## EL PASO COUNTY GRADING AND EROSION CONTROL PLAN CHECKLIST

WINSOME FILING NO. 3
 EL PASO COUNTY, COLORADO
 PRE DEVELOPMENT GESC PLAN
 GEC FINAL PLAN

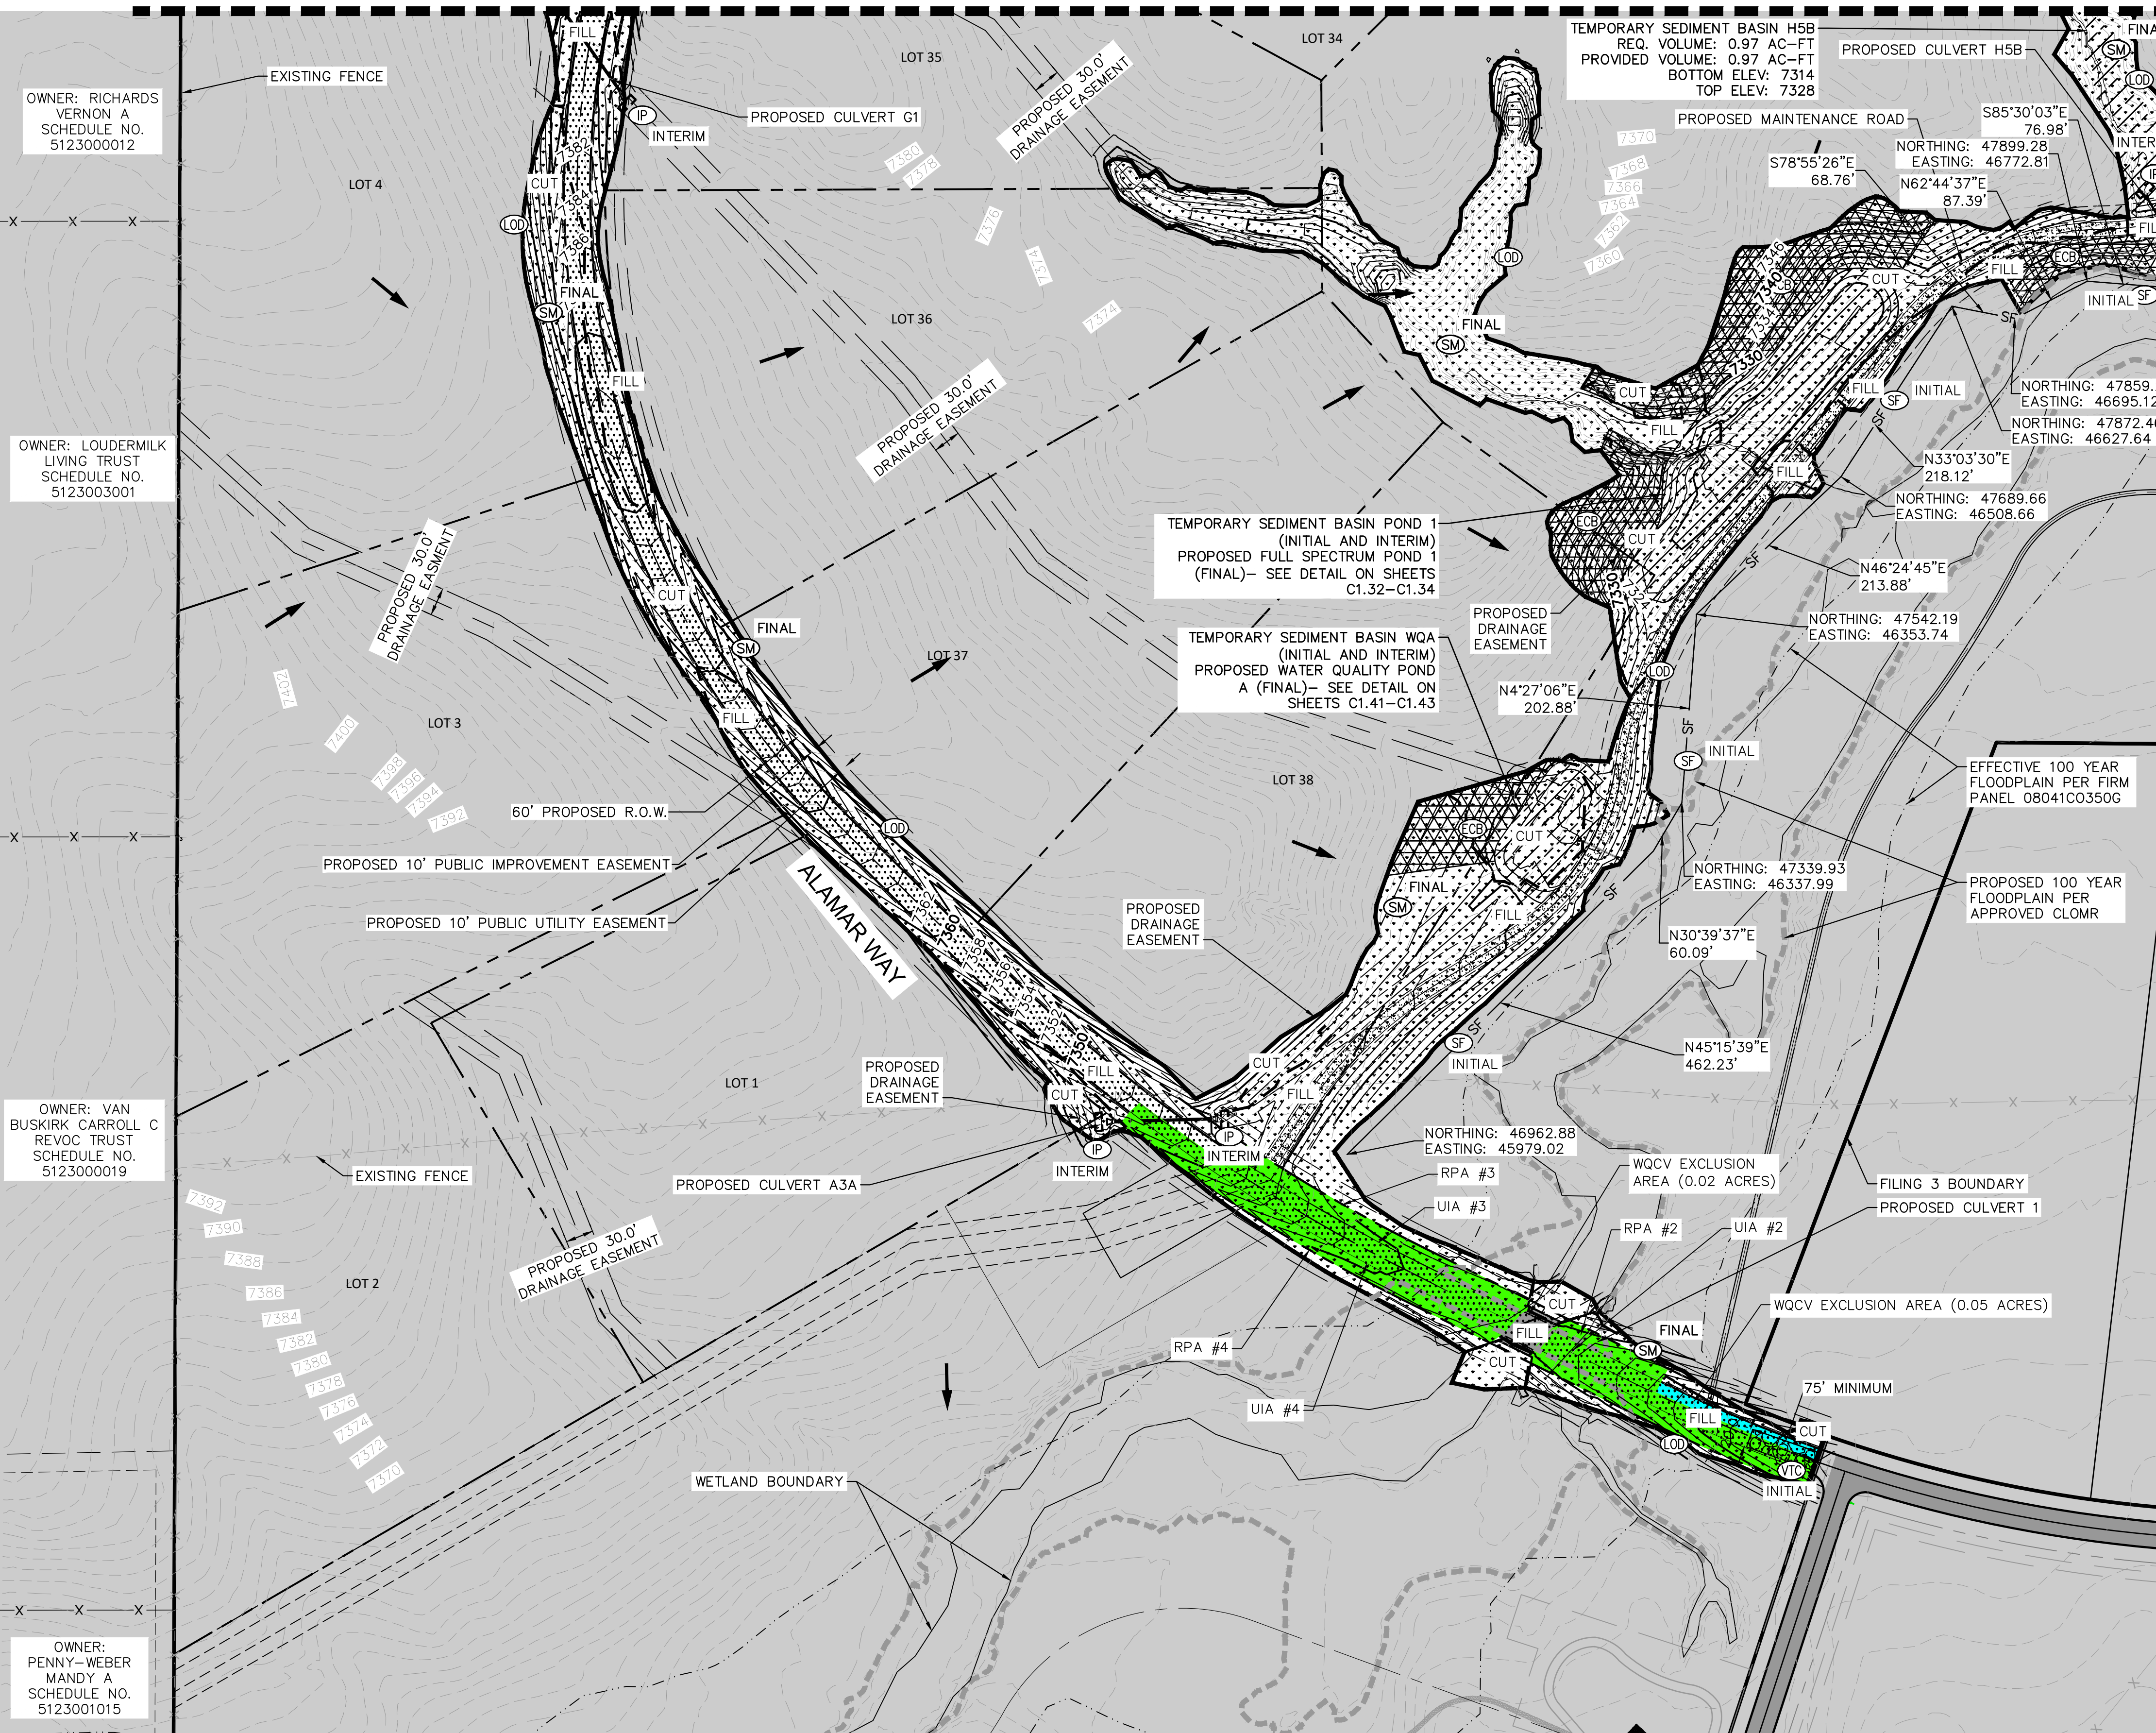
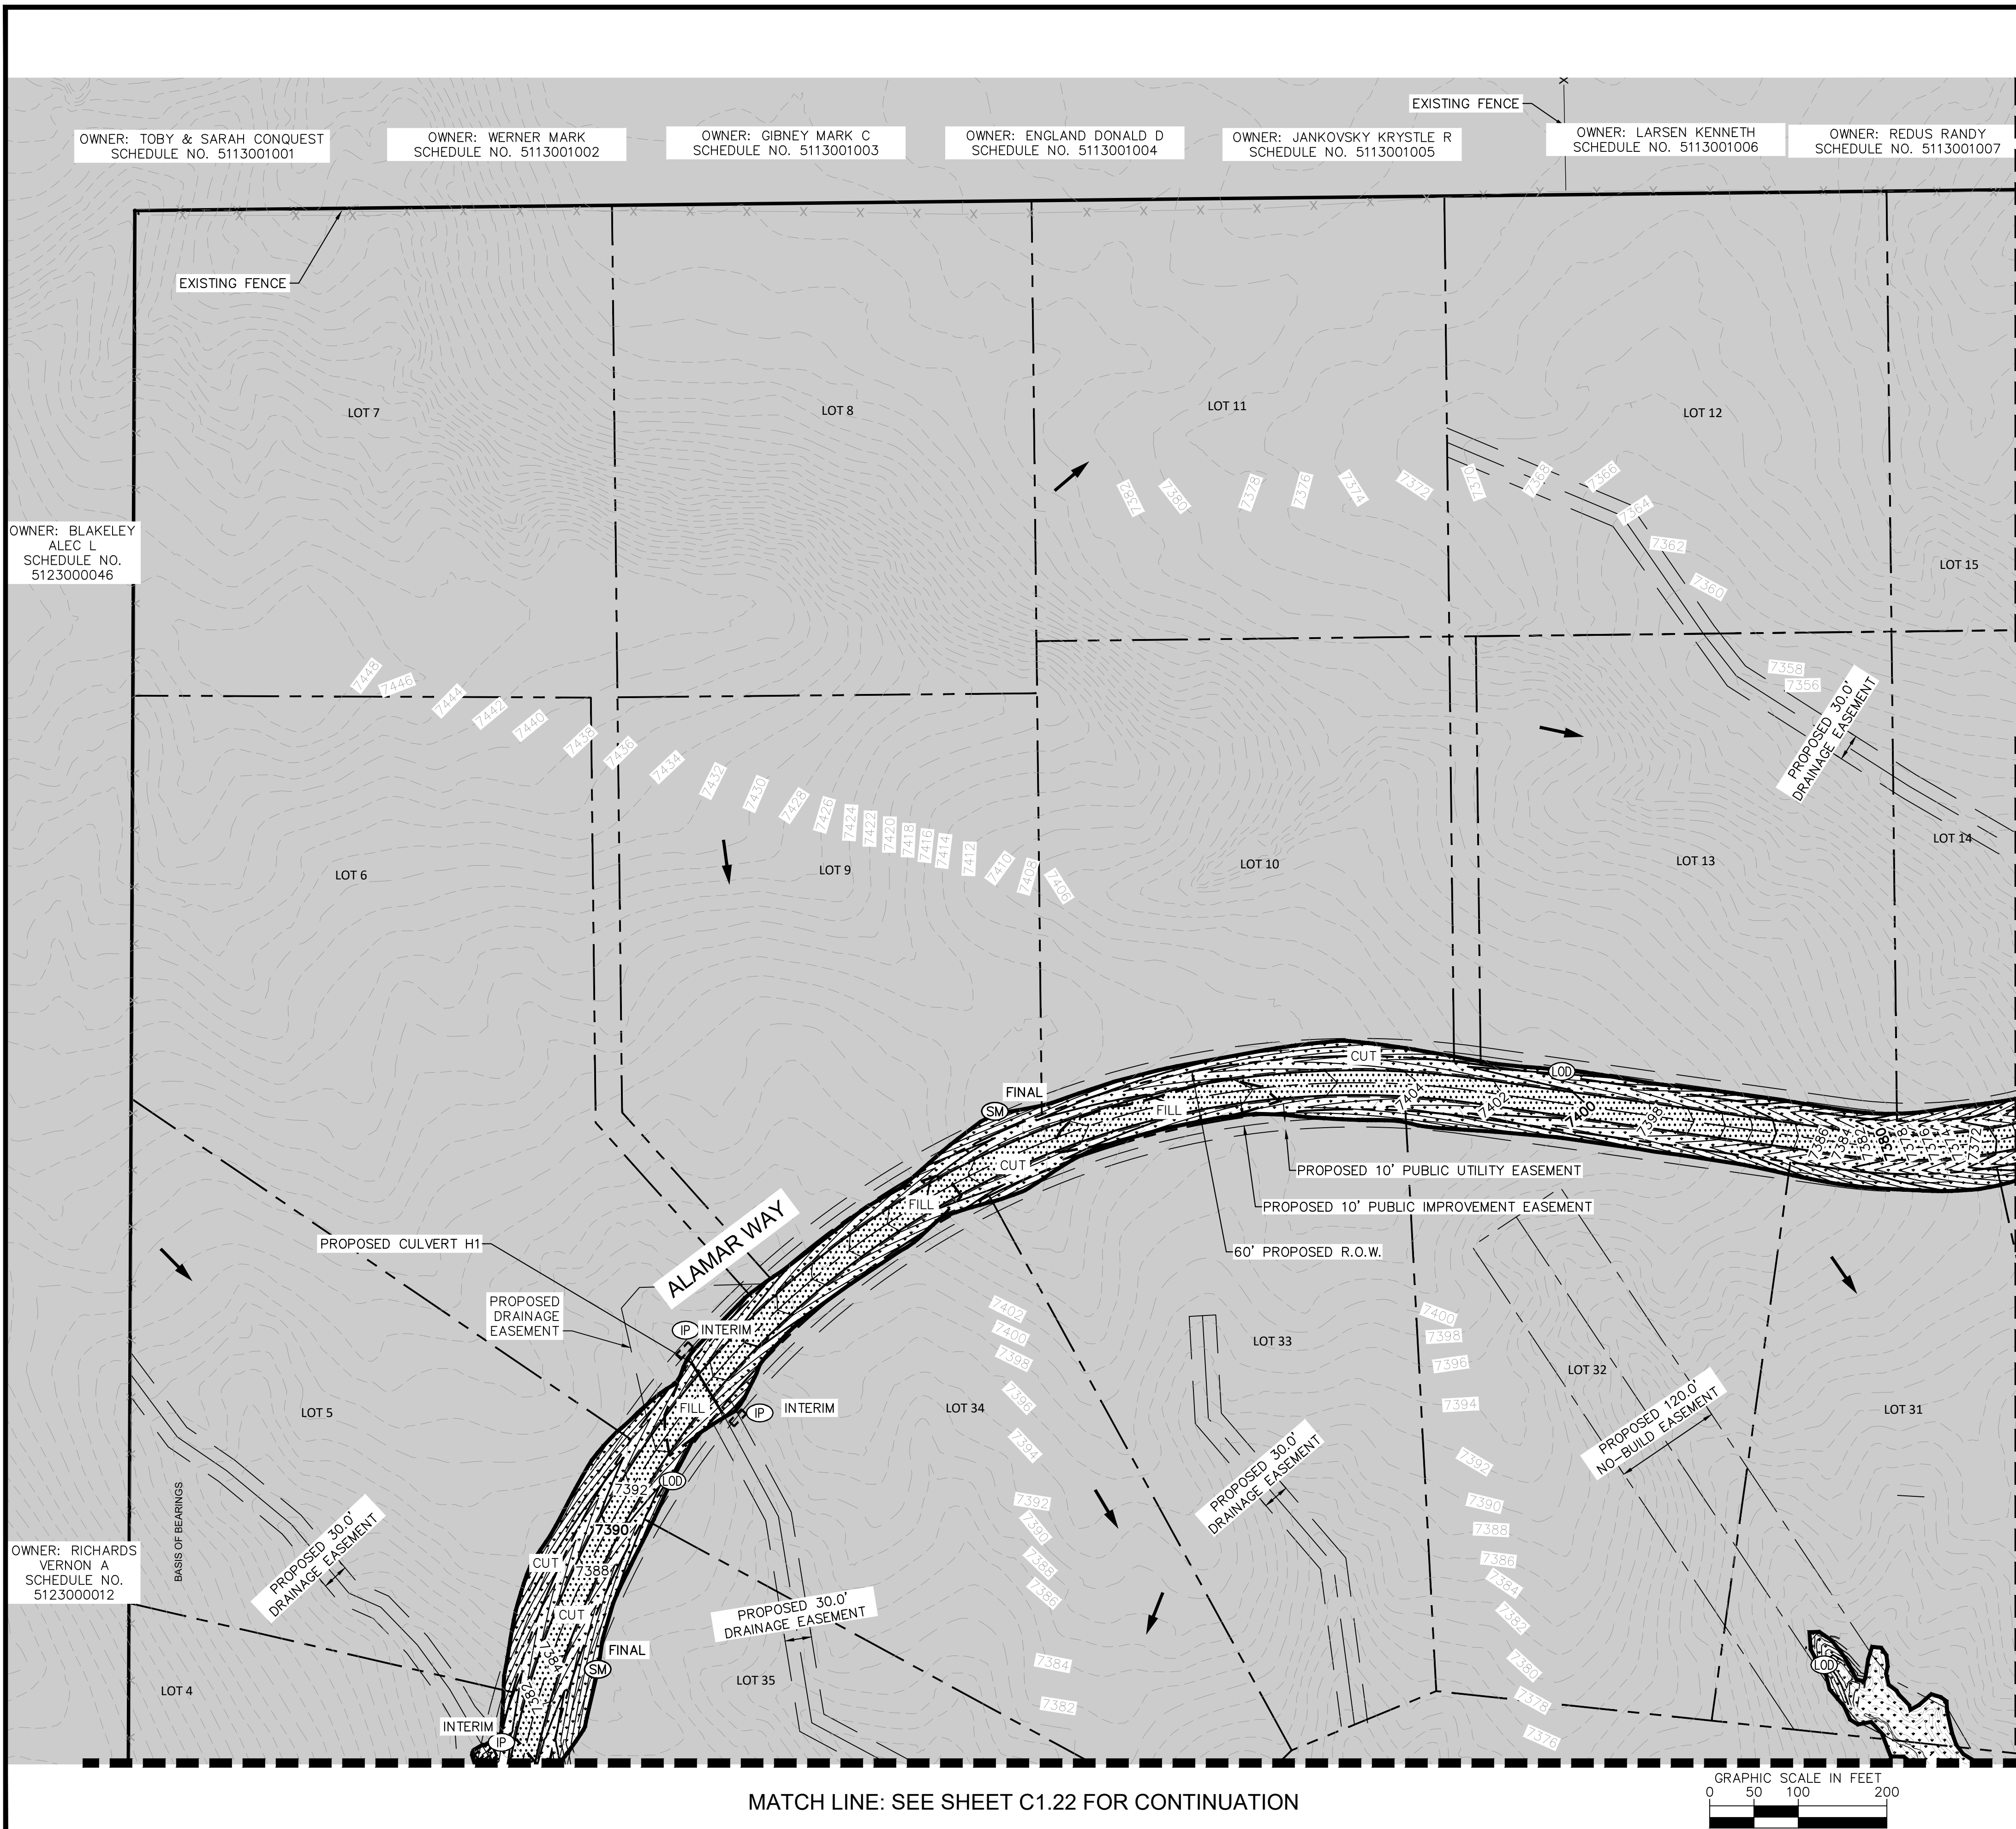
Update GEC Plans to Plat to show Runoff Reduction areas.
